**WELWYN HATFIELD BOROUGH COUNCIL
EXECUTIVE DIRECTOR - PLANNING, PUBLIC PROTECTION AND GOVERNANCE**

Application No: 6/2017/1607/FULL
Location: 1 Stanborough Mews Welwyn Garden City AL8 6DB
Proposal: Change of use from existing double garage to annex (C3)
Officer: Mr R Adenegan

Recommendation: Refused

PROJECT REF: JA/306/-

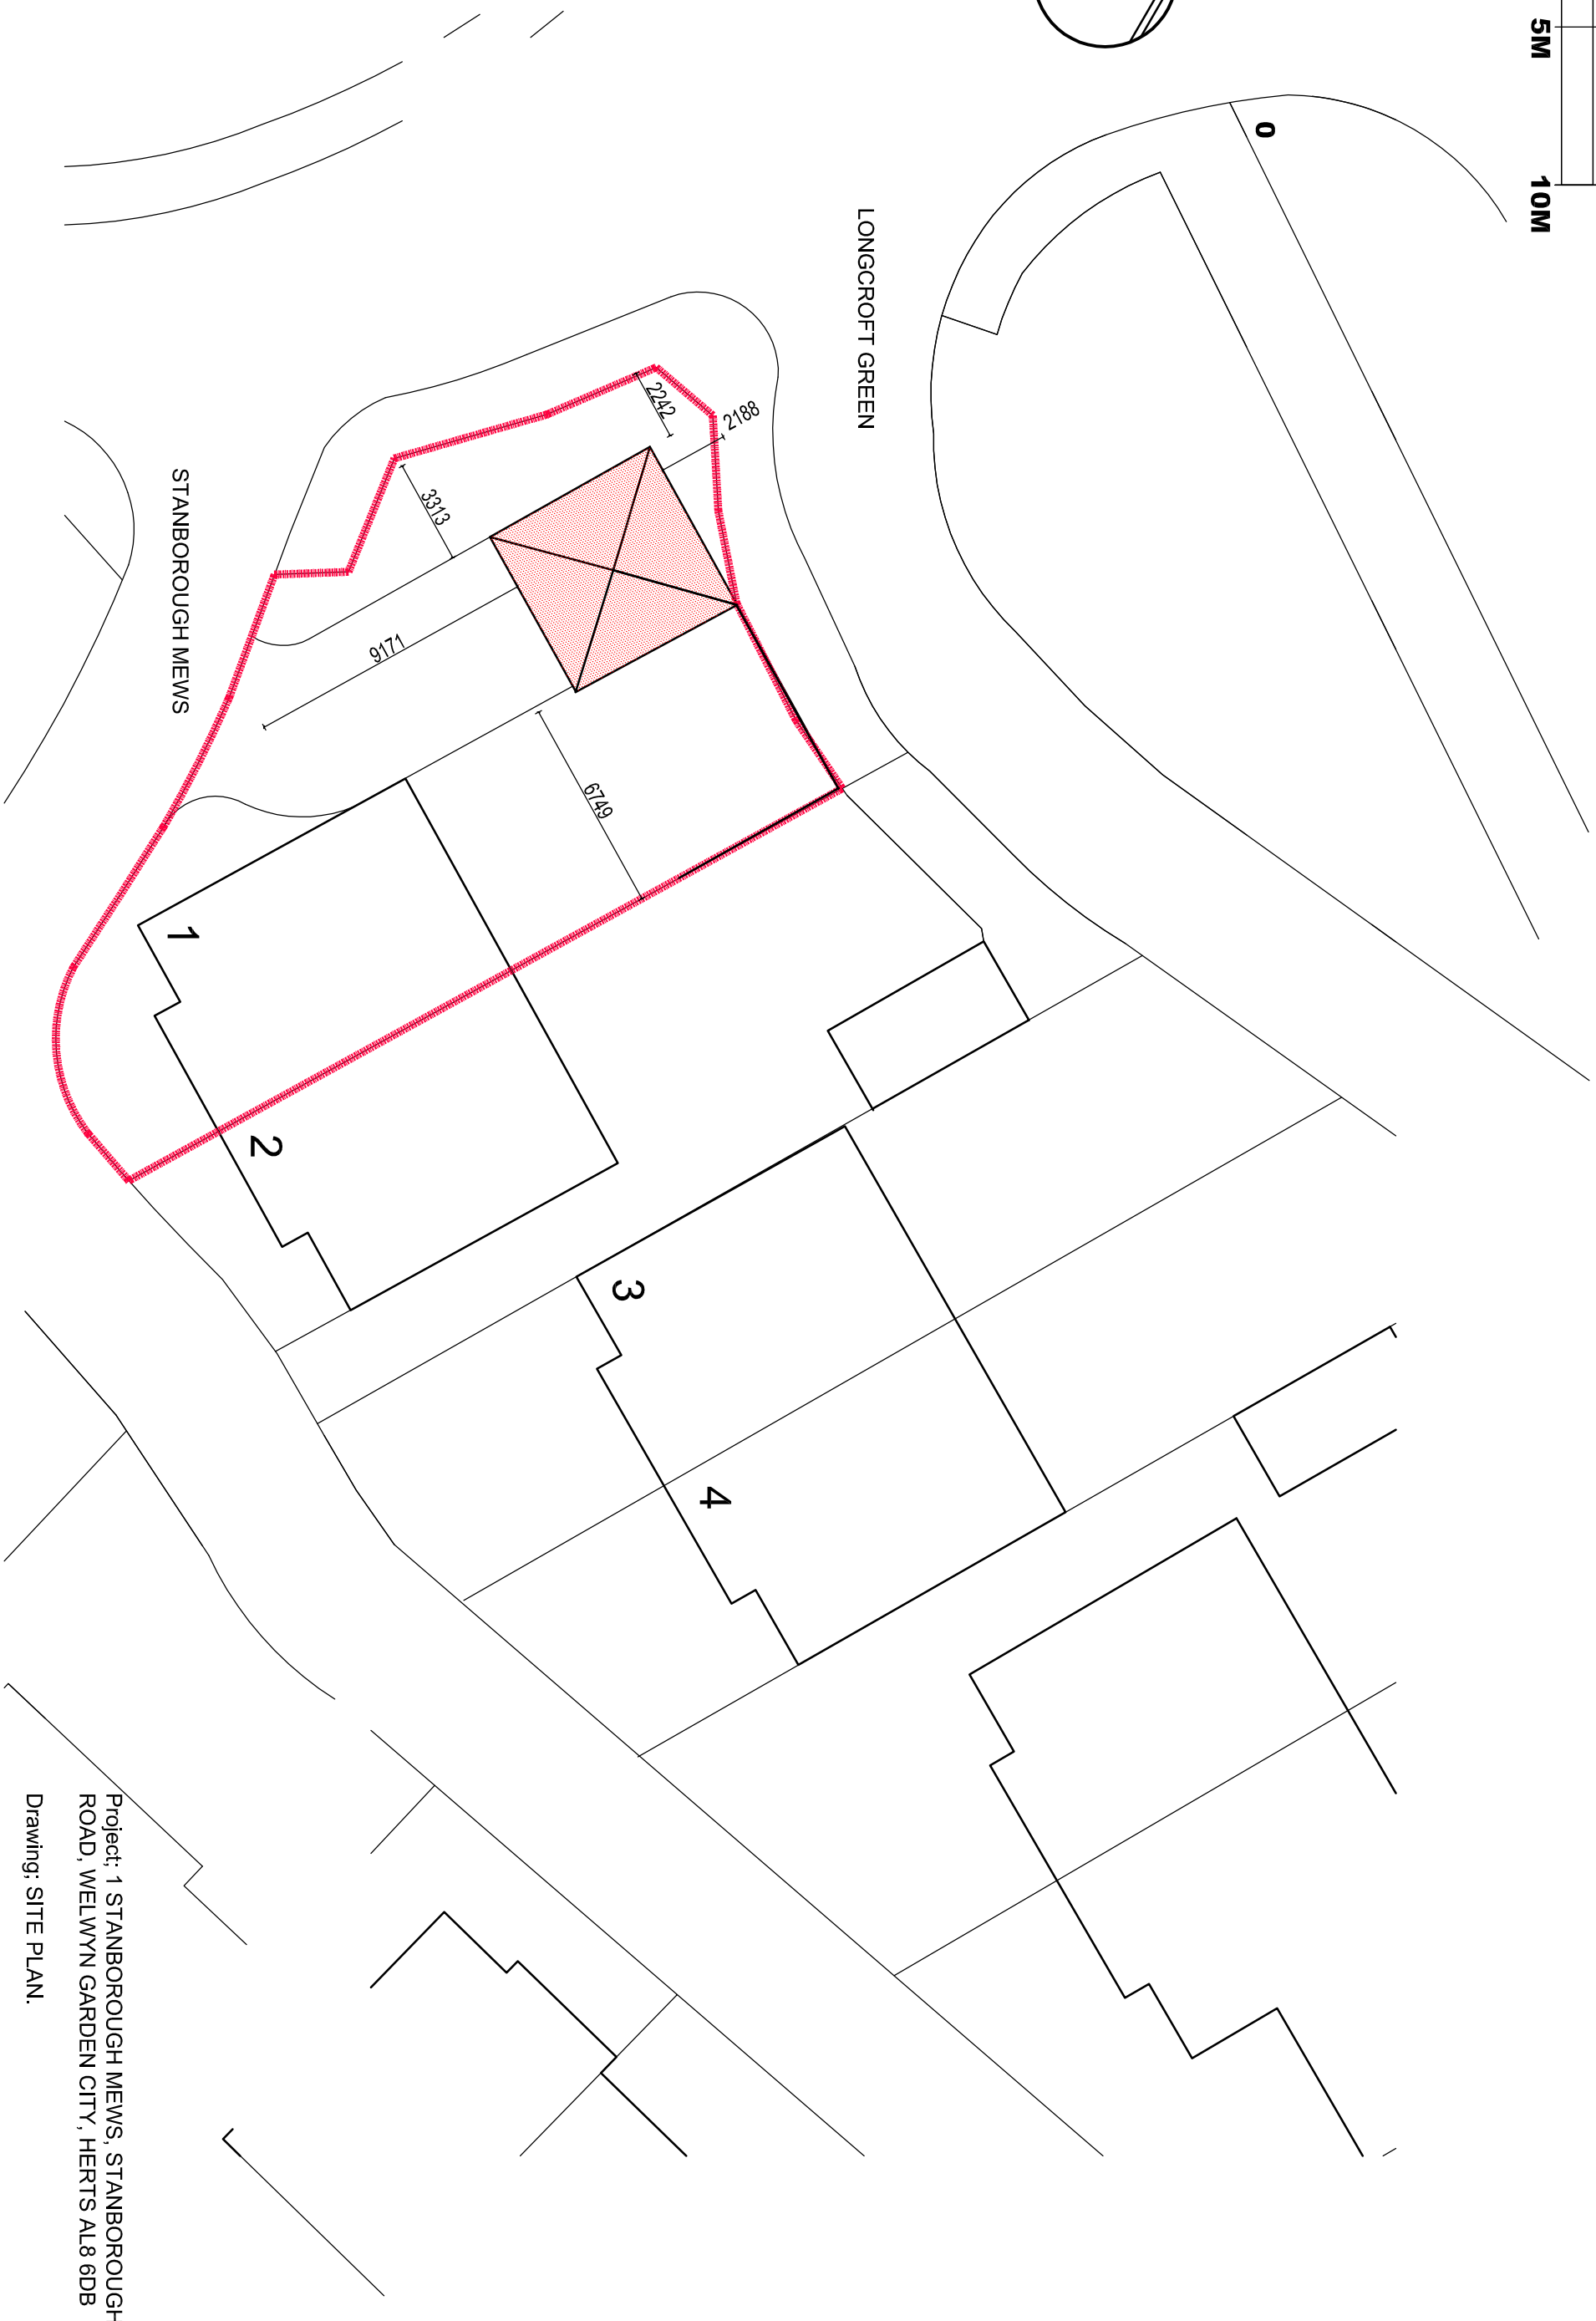
<p>Access, car parking and highway considerations</p>	<p>The existing dwelling house has five bedrooms. The proposal would result in the loss of a double garage for the viable parking of two cars. The site is within Parking Zone 4, and as such a total of 4 off-street parking spaces are required for the main house and the new accommodation. Whilst the proposed site layout plan shows 4 cars can be accommodated onsite, it would be in form of tandem parking. This arrangement would not afford independent parking for the two units contrary to Council policy and residential design guidance.</p>

It is therefore considered that the proposal would not provide an acceptable level of parking for the existing and future occupants, which would be likely to negatively affect vehicular and pedestrian flow in the street, and as such contrary to Policy M14 of the Welwyn Hatfield District Plan 2005.
Landscaping Issues	None
Any other considerations	
Conclusion	
The proposal has been considered based on the information provided by the applicant. Whilst there is reference to the retention of the new accommodation as part existing residential dwelling, the applicant has indicated that the proposal is for independent use. As such, the change of use application has been assessed as an independent unit and not in accordance to stated local and national policies. The development would not maintain the character of the area nor preserve the amenity of the occupiers of the existing and future occupants. The accommodation as proposed will not provide a suitable, sustainable and quality living accommodation for its future occupants, and as such would be contrary to the principles contained in the National Space Standard, Policy D1, D2, M14 and GBSP2 of the Welwyn Hatfield District Plan 2005, Policy SADM11 of the emerging Local Plan 2016 and the National Planning Policy Framework, Supplementary Design Guidance of the Welwyn Hatfield District Plan 2005, Supplementary Planning Guidance, Parking Standards 2004, Interim Policy for Car Parking Standards and Garage Sizes 2014.
